**Site: Brookfield Barn- Land North Of Newlands Delaware Farm Hever Road Edenbridge
Kent TN8 7LD**

Proposal: Non-Material Amendment to 23/01907/MMA- Amendment to 22/02926/CONVAR related to 21/01300/FUL for conversion of existing building to a detached dwelling with associated access and landscaping.

Please find enclosed revised drawings for a Non-Material Amendment to SE/23/01907/MMA. The following plans are enclosed to address the amendments sought:

Project: Newlands, Delaware Farm Hever Road, Edenbridge. TN8 7LD	Date: March 2021
Drawing Title: Proposed Layouts	Scale: Noted @ A1
Drawing Number: 20017-P-800	Rev: D
Issued for Planning	October 2023

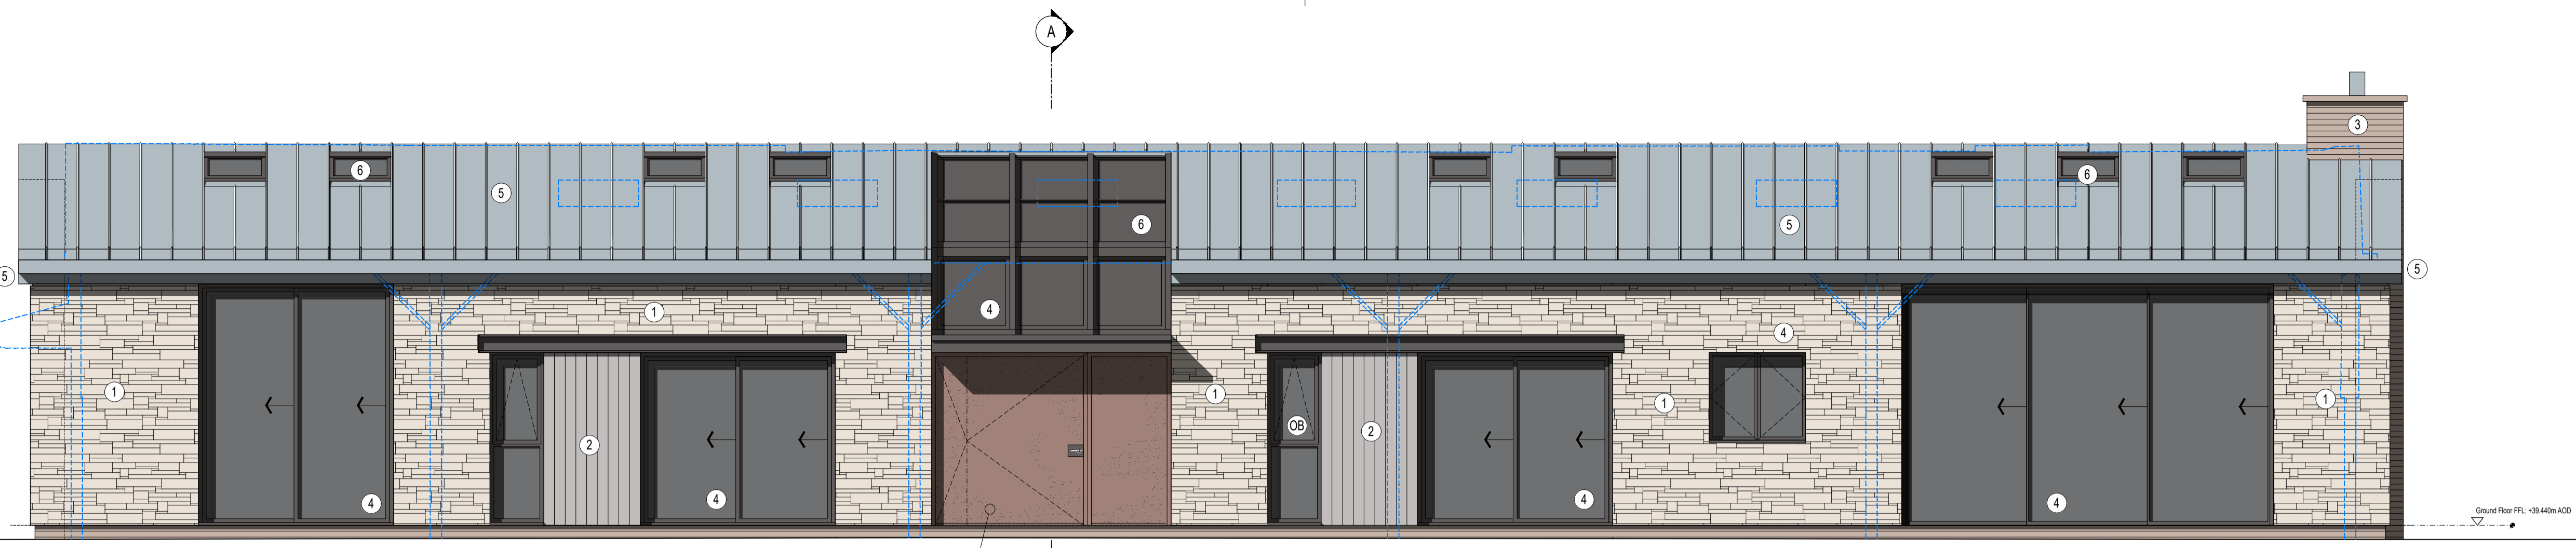
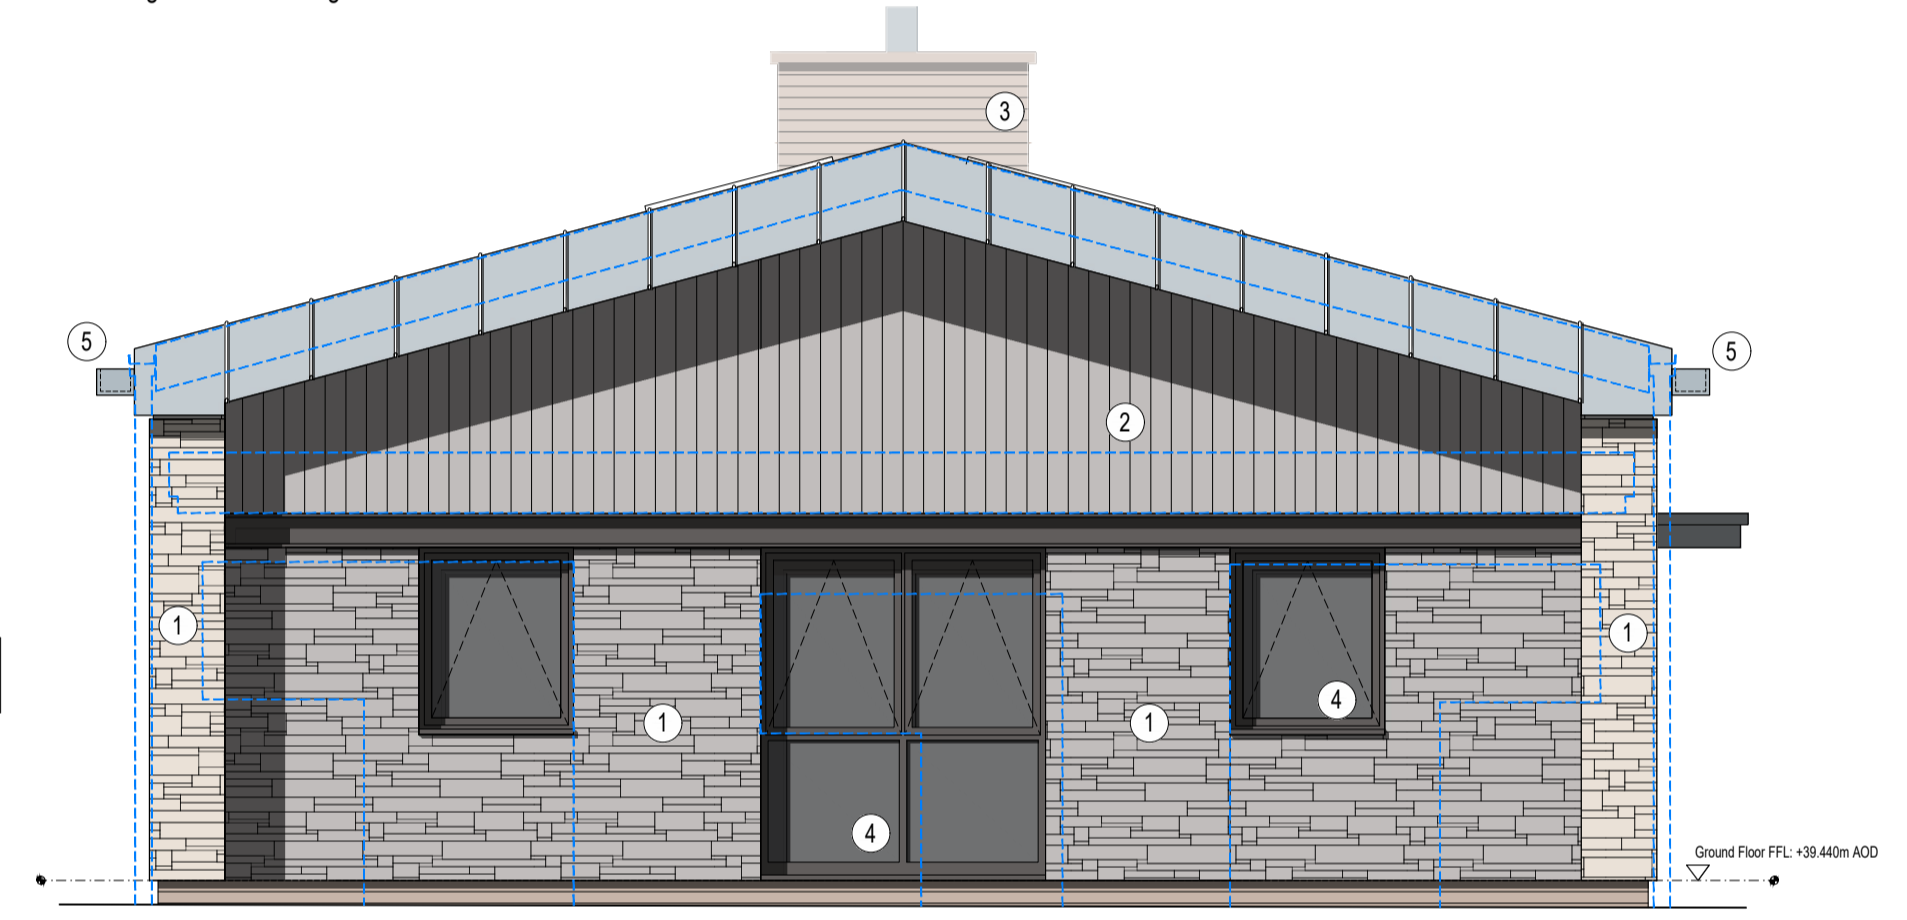
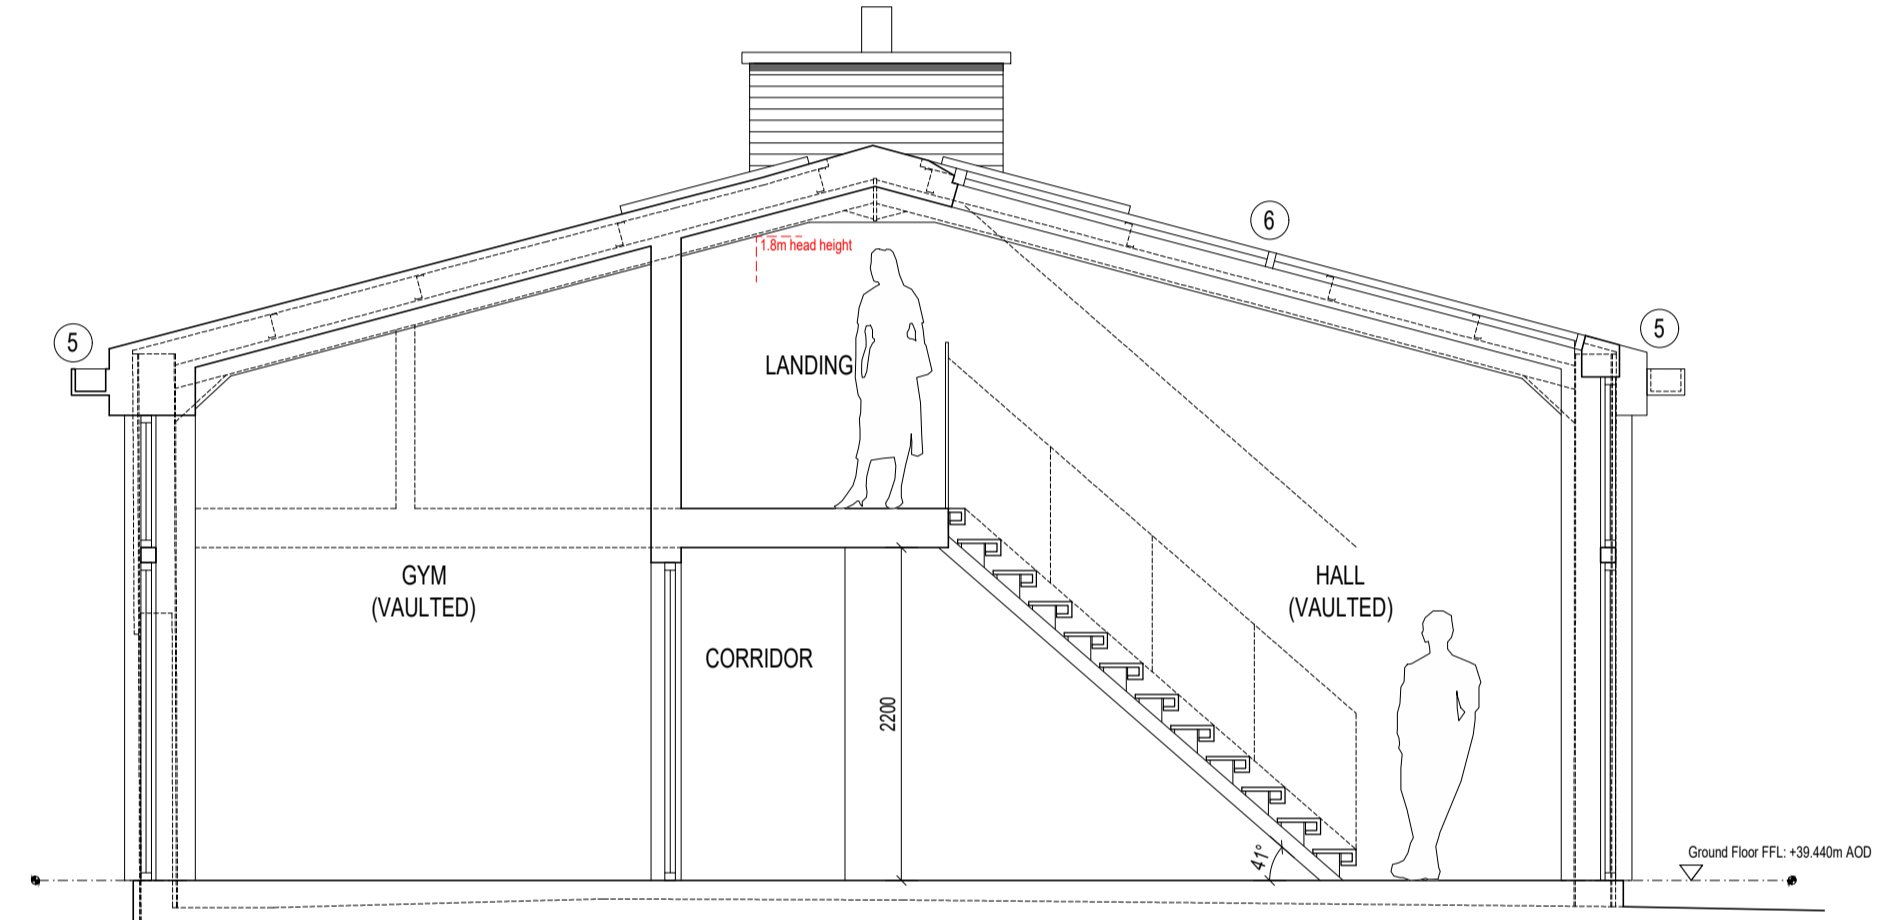
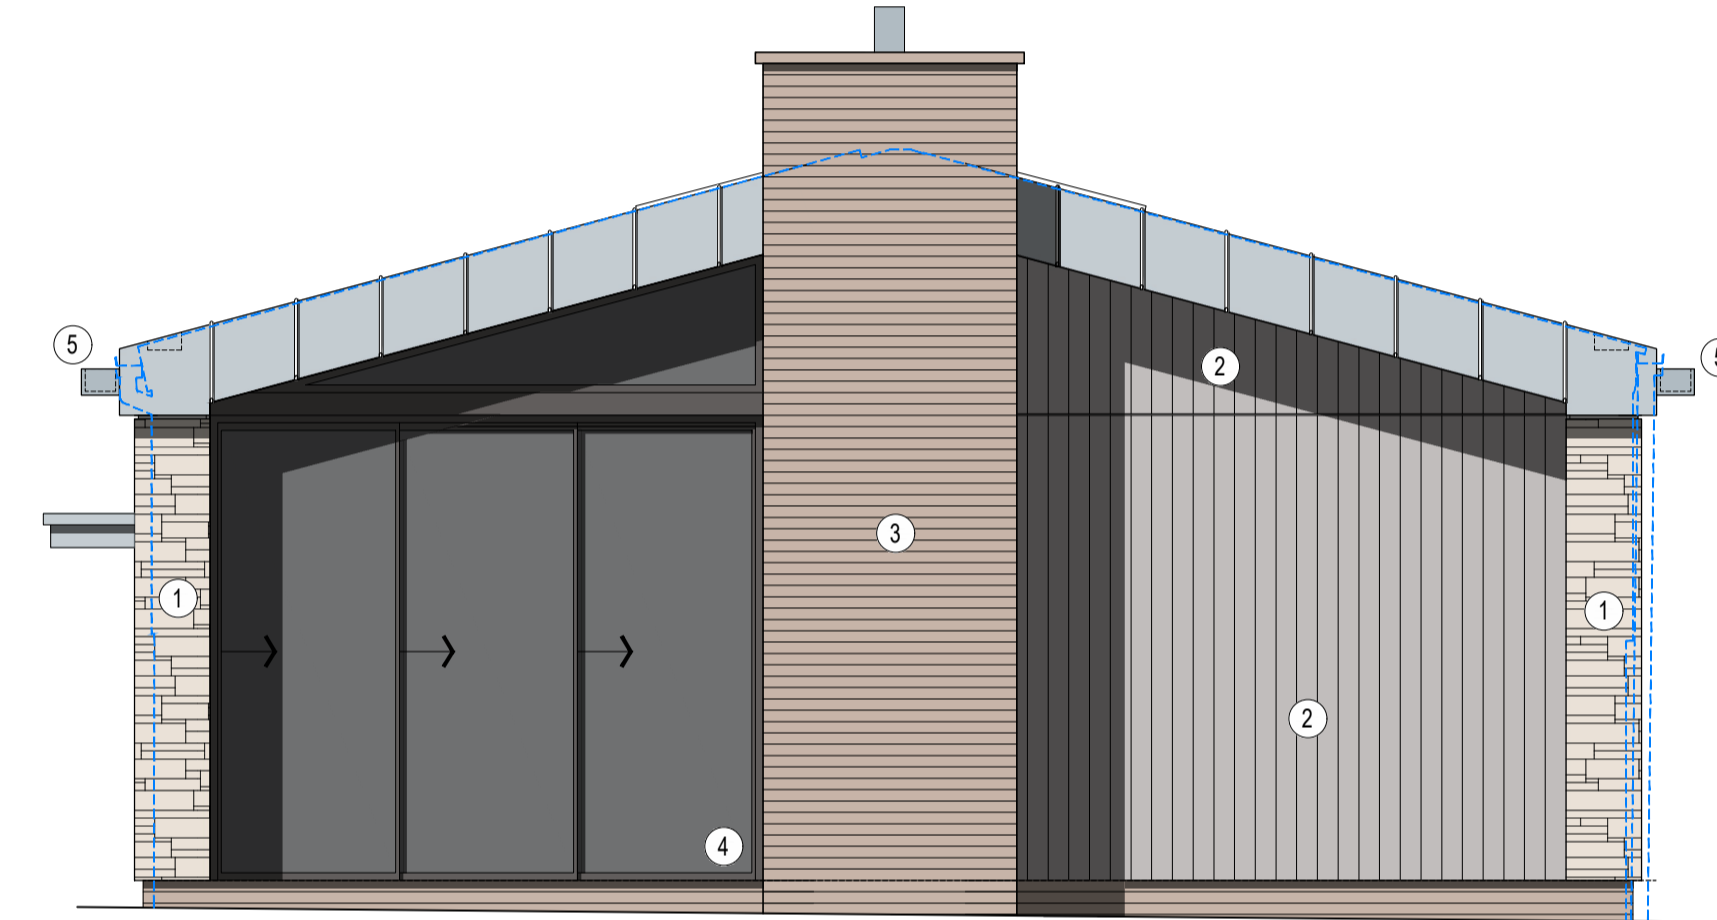
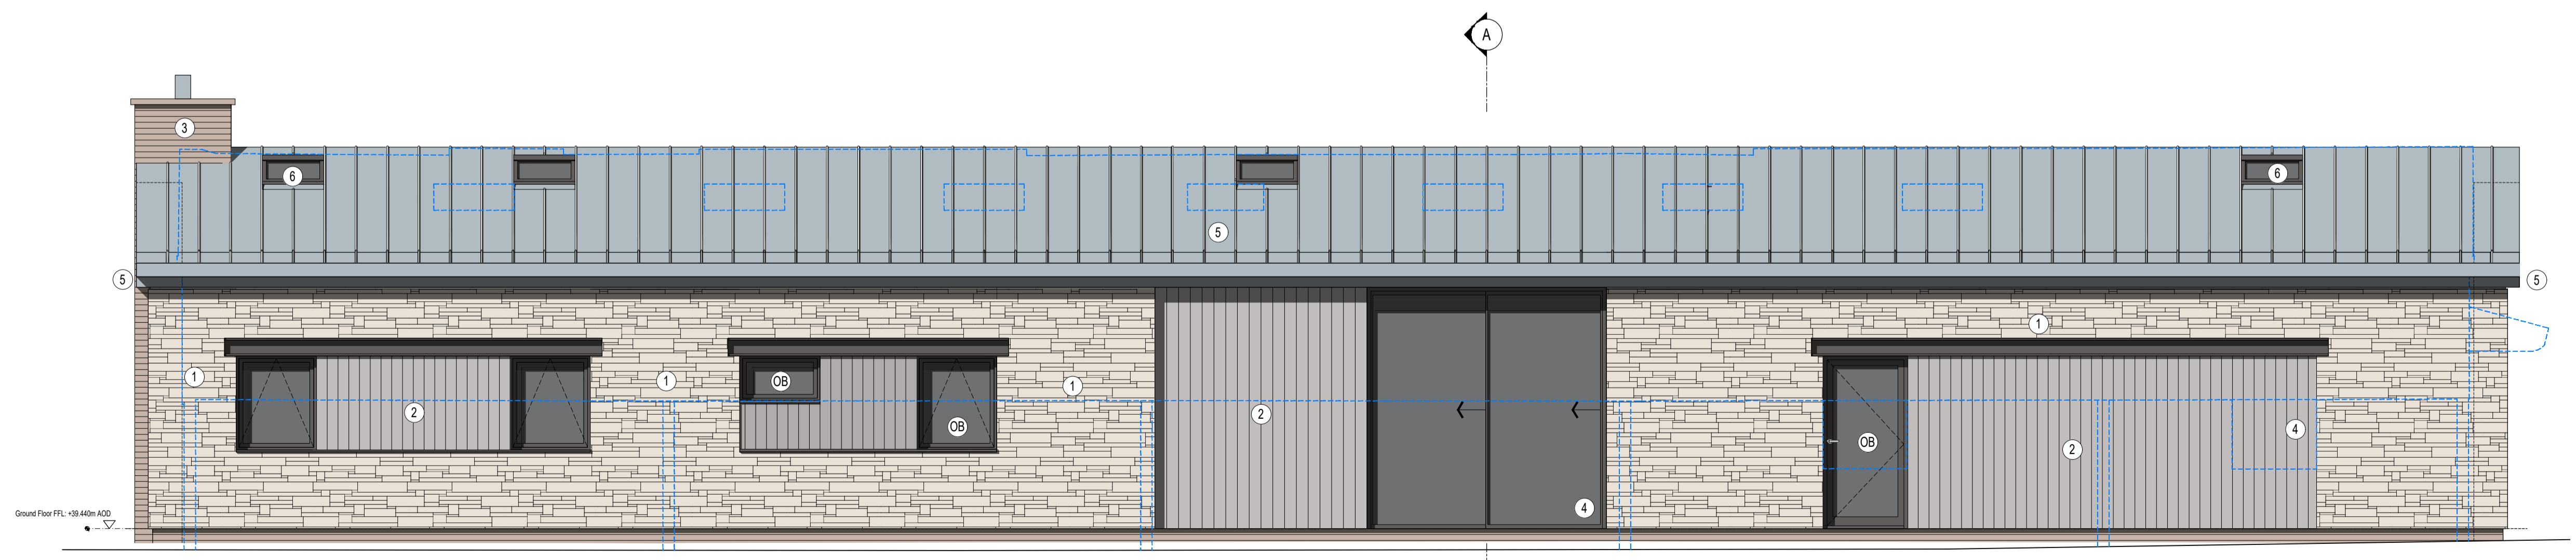
- Deletion of 2 roof lights to the west(front facing) roof slope
- Switched position of en-suite and dressing area to Bed 1
- Obscure glazing to west (front elevation) boot room door

- Deletion of front elevation window serving previous dressing area and continuation of larch cladding
- Bed 3 bi-fold door mechanism altered to sliding (no change in aperture size)

- Right hand glazed panel of the front door altered to be solid panel (no change in aperture size)
- Change to east facing (rear elevation) kitchen window from top hung single casement to French casement (no change in aperture size)

- Bed 2 bi-fold door mechanism altered to sliding (no change in aperture size)
- Utility room/boiler room window reduced to a high-level aperture and continuation of larch cladding beneath

- Reduction in height of the west facing (front elevation) snug windows, with continuation of stone cladding beneath.
- Reduction in height of en-suite and Bed 1 windows, and continuation of stone facing beneath
